## A66 NTP: Cumbria County Council - PRINCIPAL AREAS OF DISAGREEMENT SUMMARY STATEMENT – UPDATE FOR DEADLINE 3

Drawing Title: Classification of Roads Plan Regulation 5(2)(o)
Sheet 1 of 1

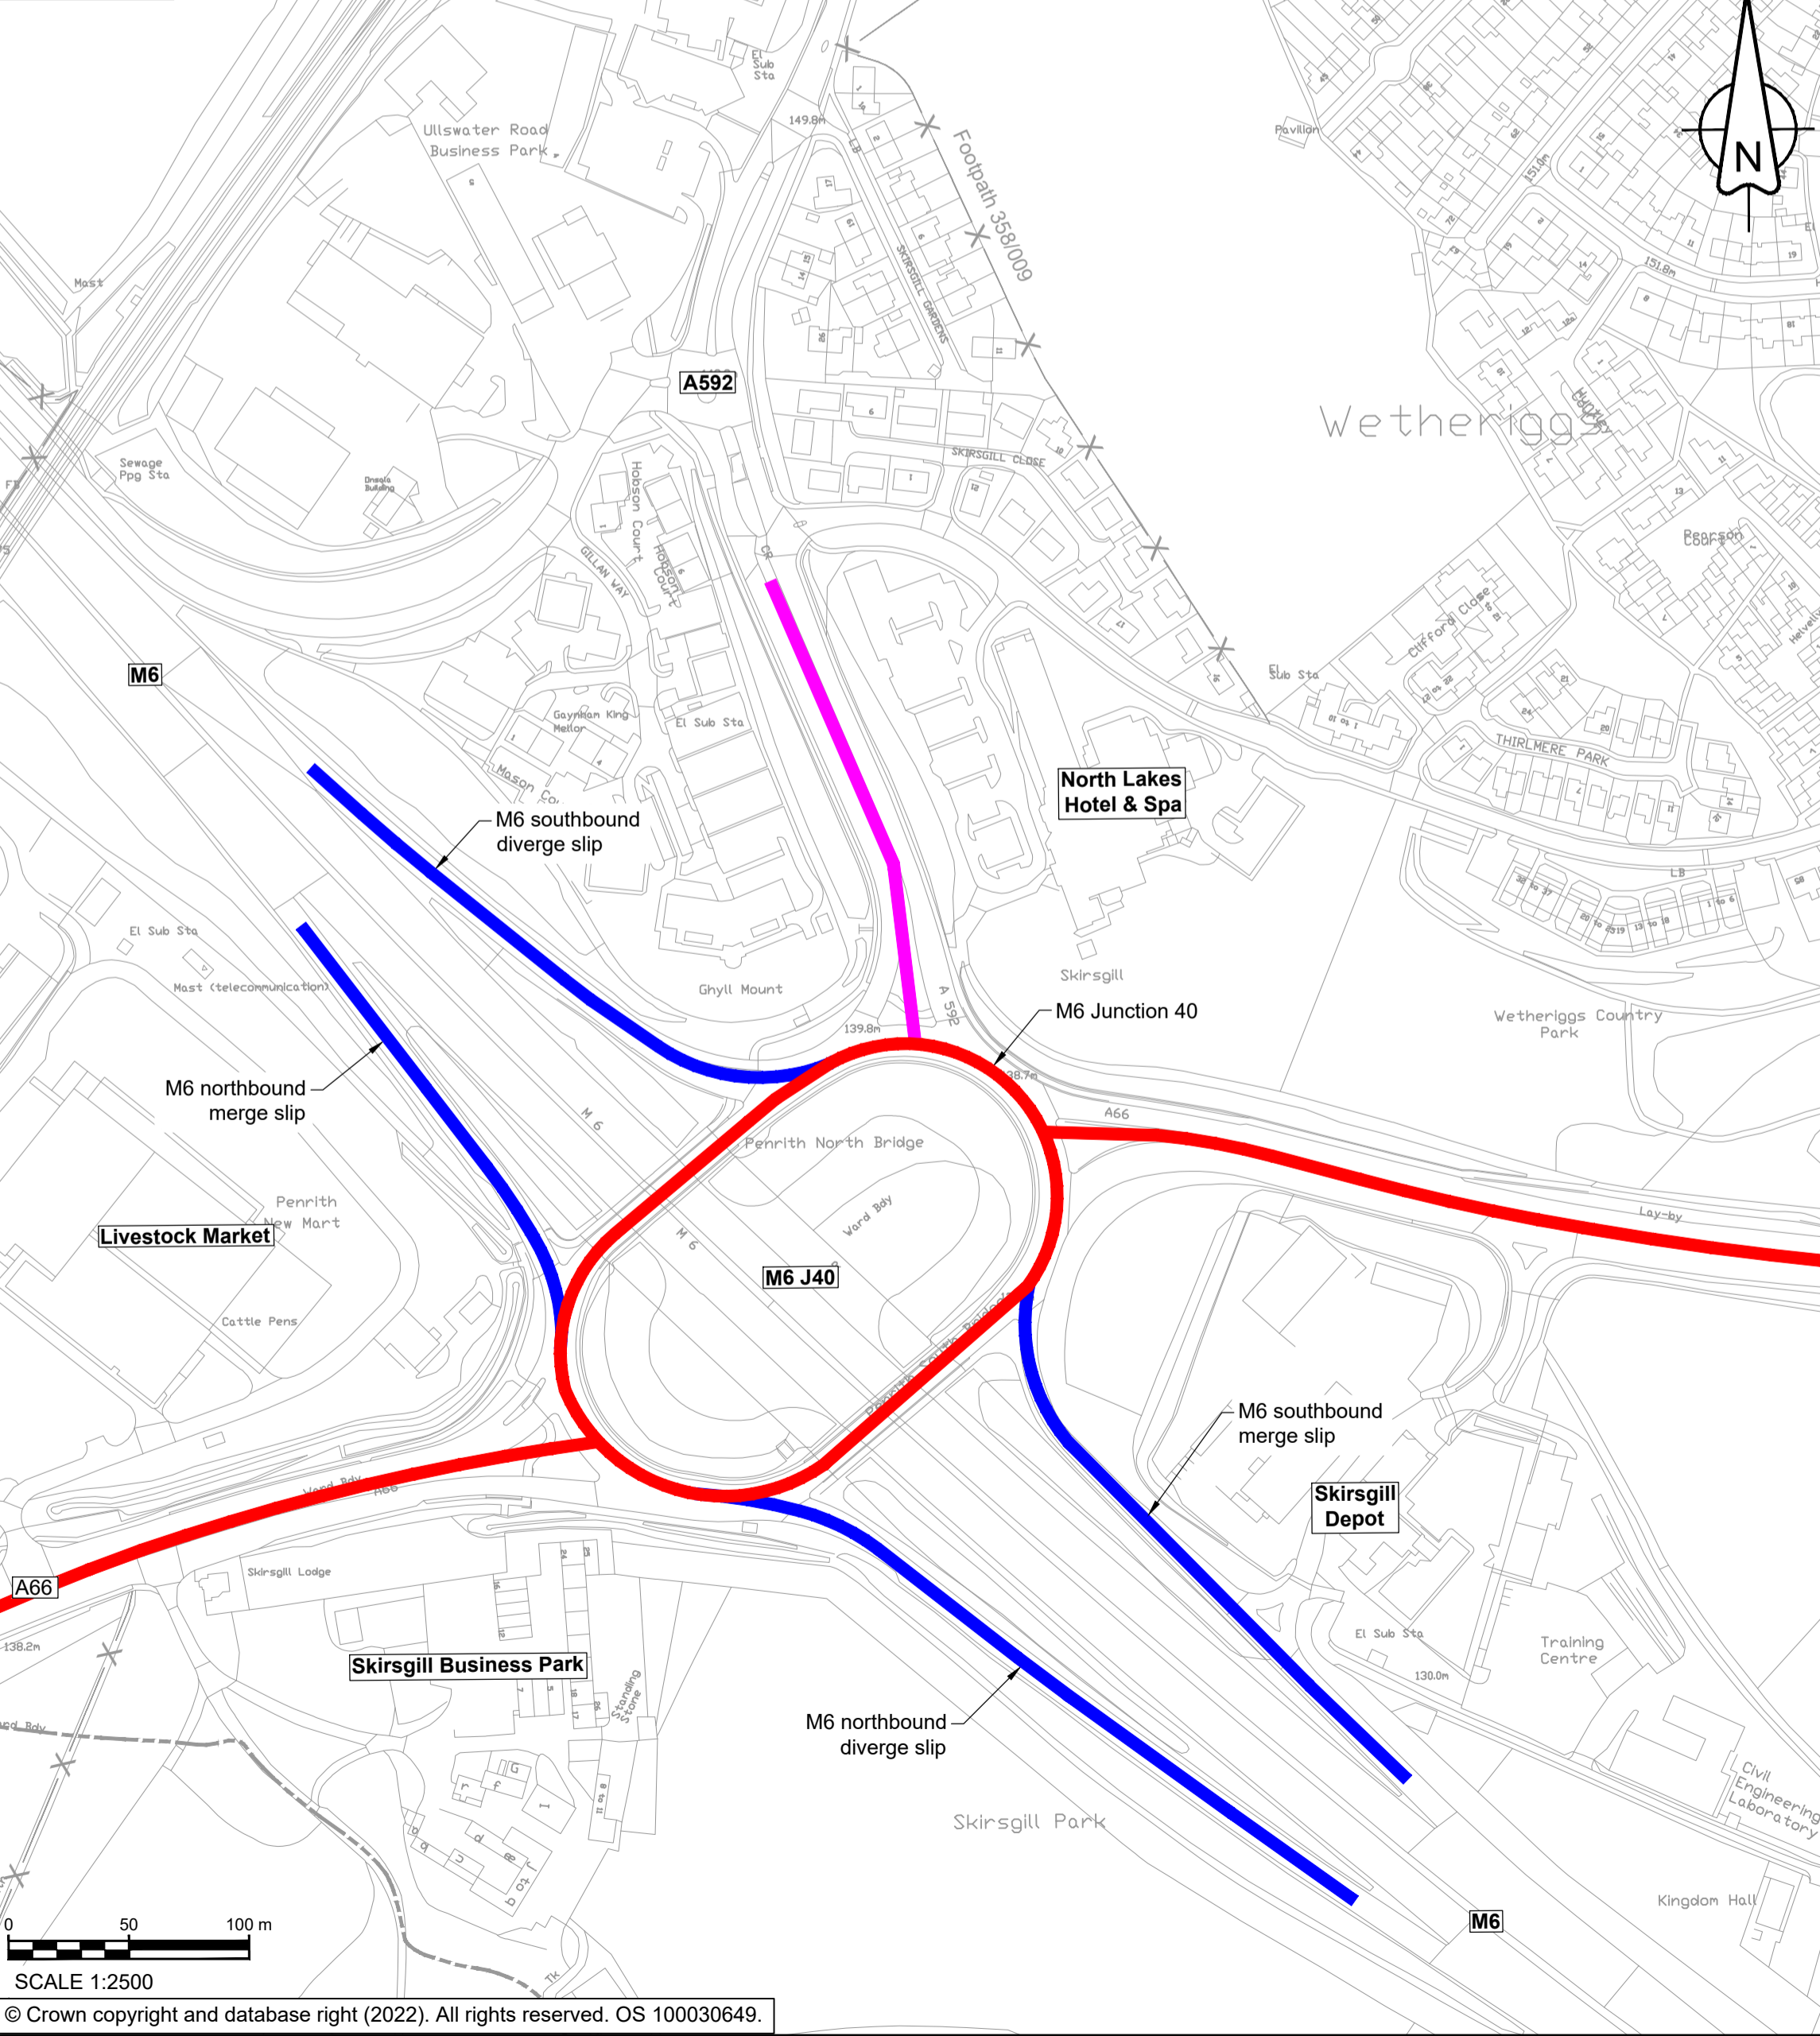
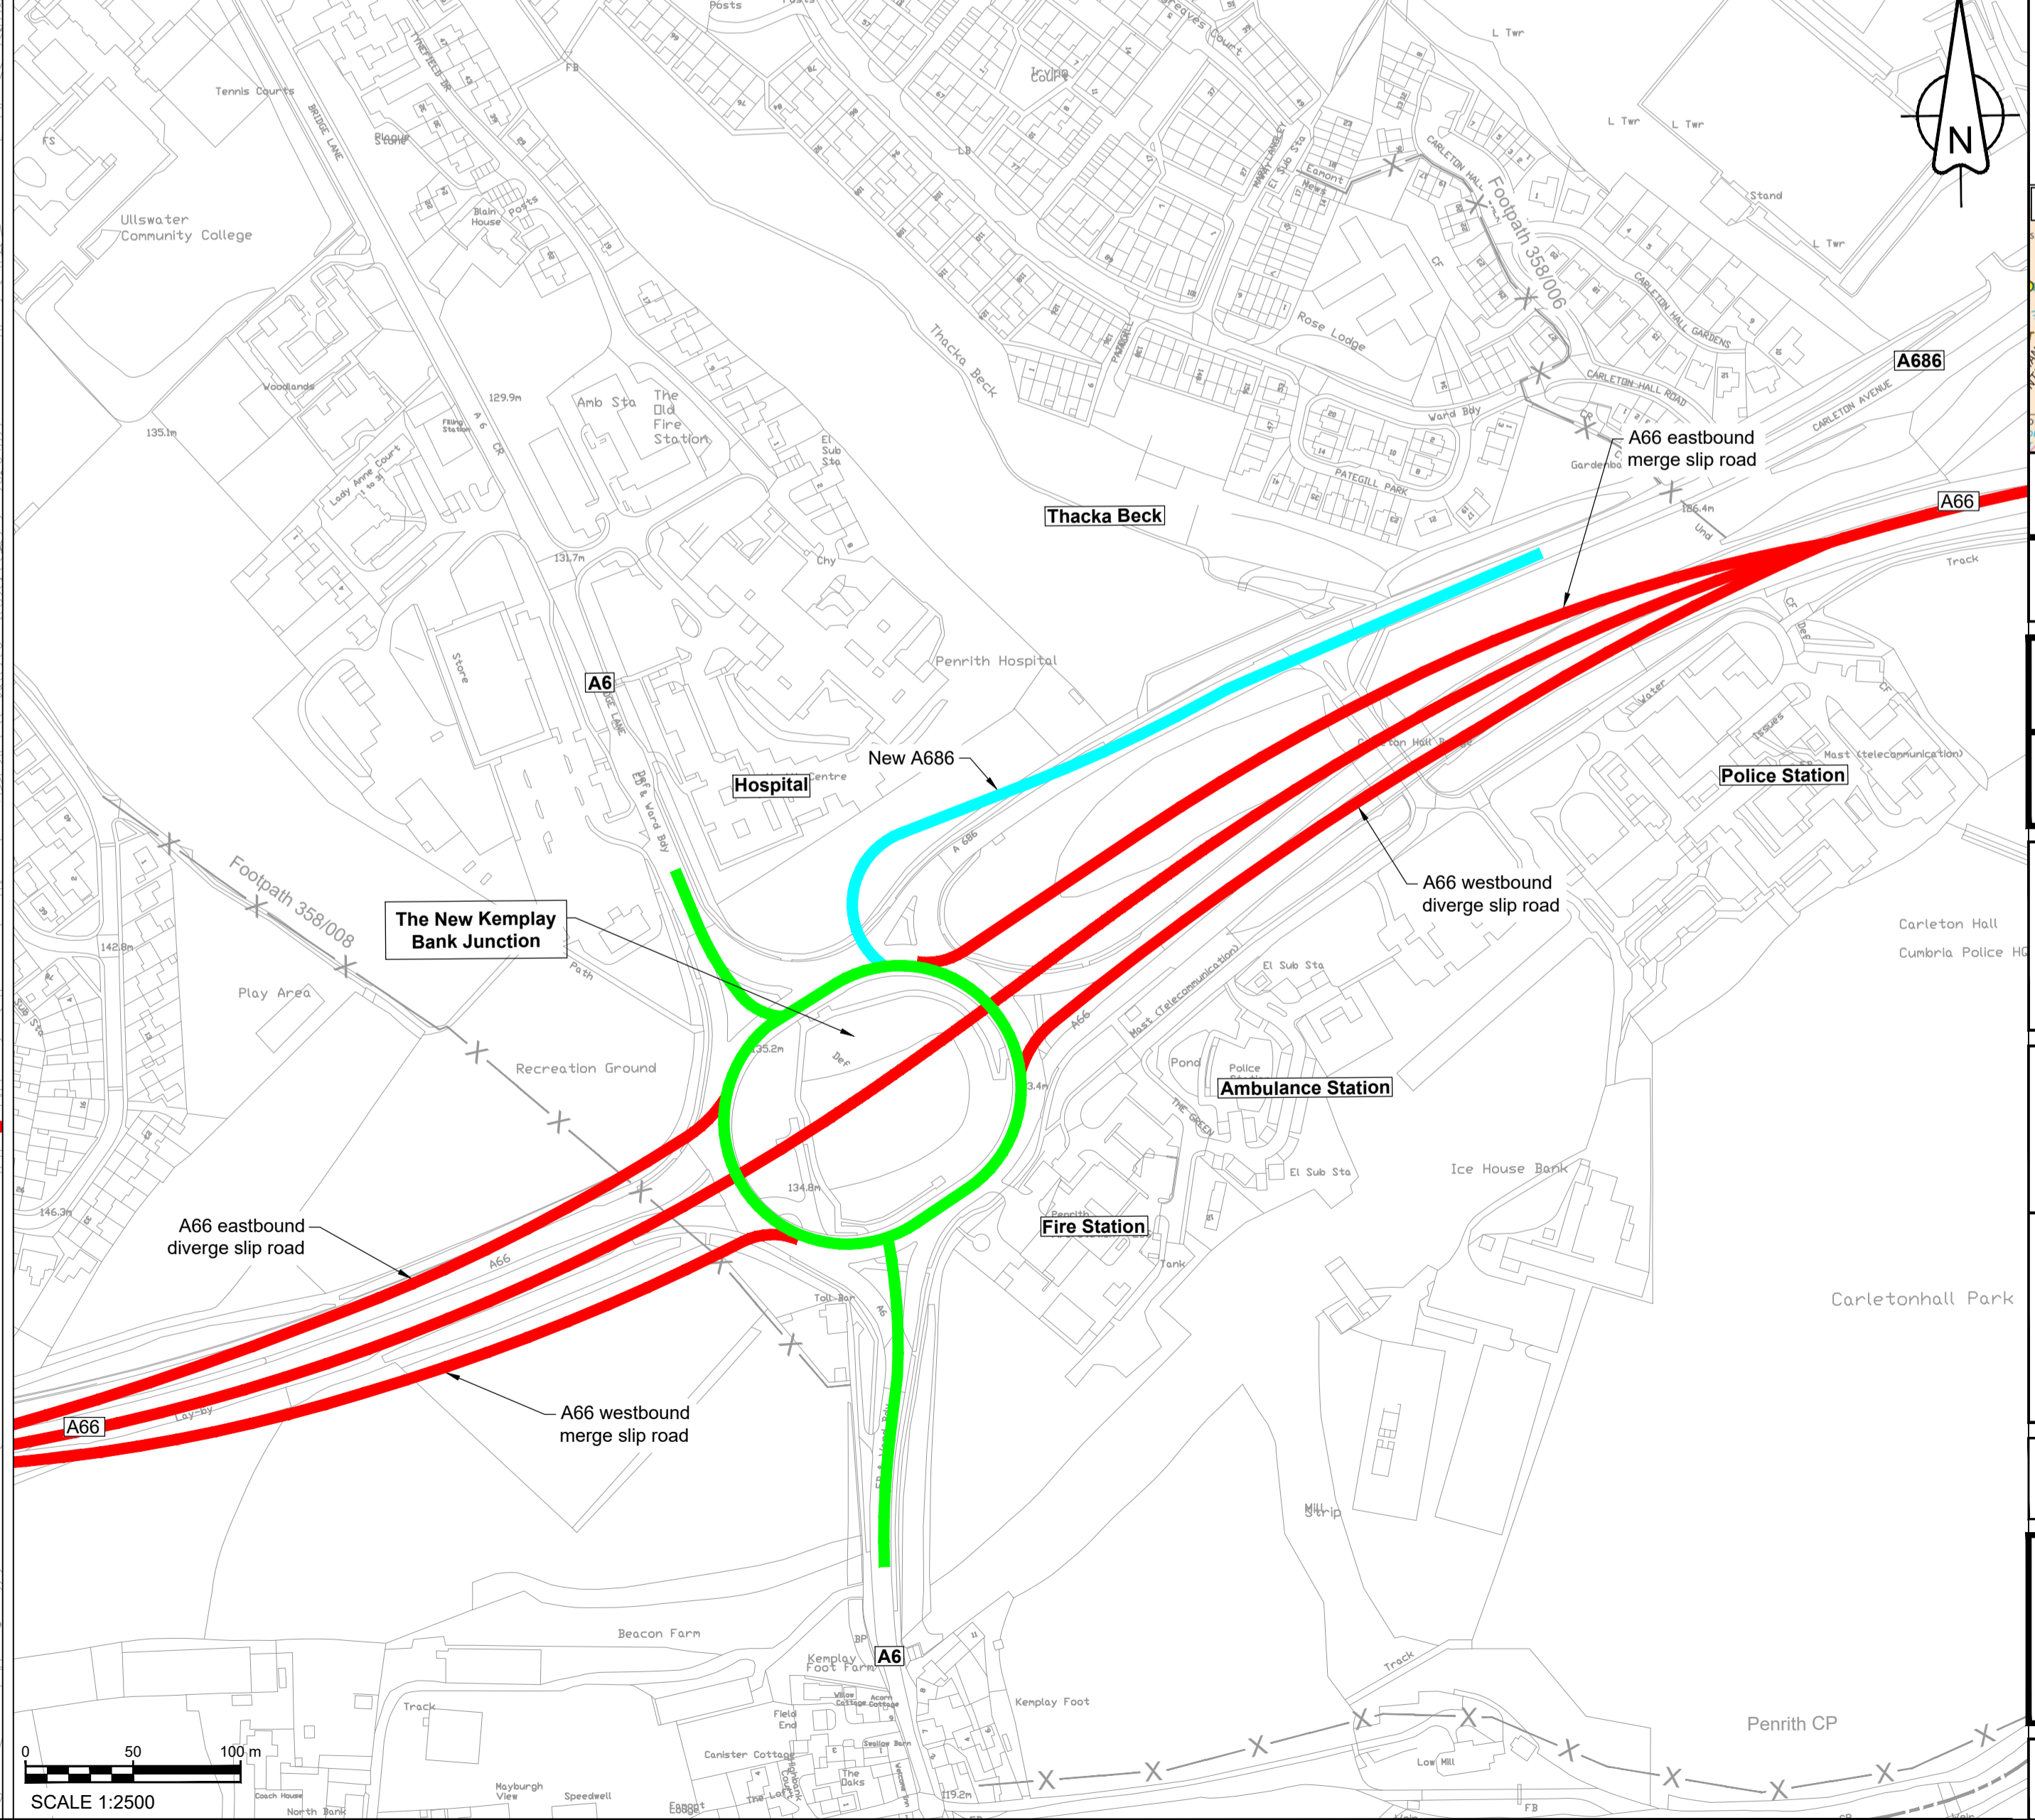
4	<p><b>Penrith Area</b></p> <p>M6 J40 Cycling and Walking crossing provision do not appear appropriate or in accordance with LTN 1/20. The proposals result in a slow and lengthy journey across the junction and are likely discourage sustainable modes. The proposals for the cycle route linking J40 and Kemplay Bank are unclear</p>	The proposals need to be amended to comply with LTN 1/20, then reviewed by the Council to confirm agreement	The Councils will continue to engage with the Applicant as the design progresses to ensure that the standard of provision provided meets the standards within LTN 1/20.
5	<p><b>Penrith Area</b></p> <p>Skirsgill Depot Proposed new access road to Skirsgill Depot is not agreed due to potential adverse impact of proposals on the delivery of CCC operational services (CTOT (customer transport), highway depot operations, county stores, buses, winter maintenance - during construction works and in operation</p>	<p>Discussion needed to ensure suitability of proposals and design integration with the operational usage of the depot. Incorporation of agreed solution in scheme design Need to review how the construction impacts will be managed in order minimise impacts and ensure continued viable operation of the site. Confirm suitability of junction design for depot usage, including CTOT (Community Transport) buses</p>	Until detailed designs are available the Councils cannot confirm their position.
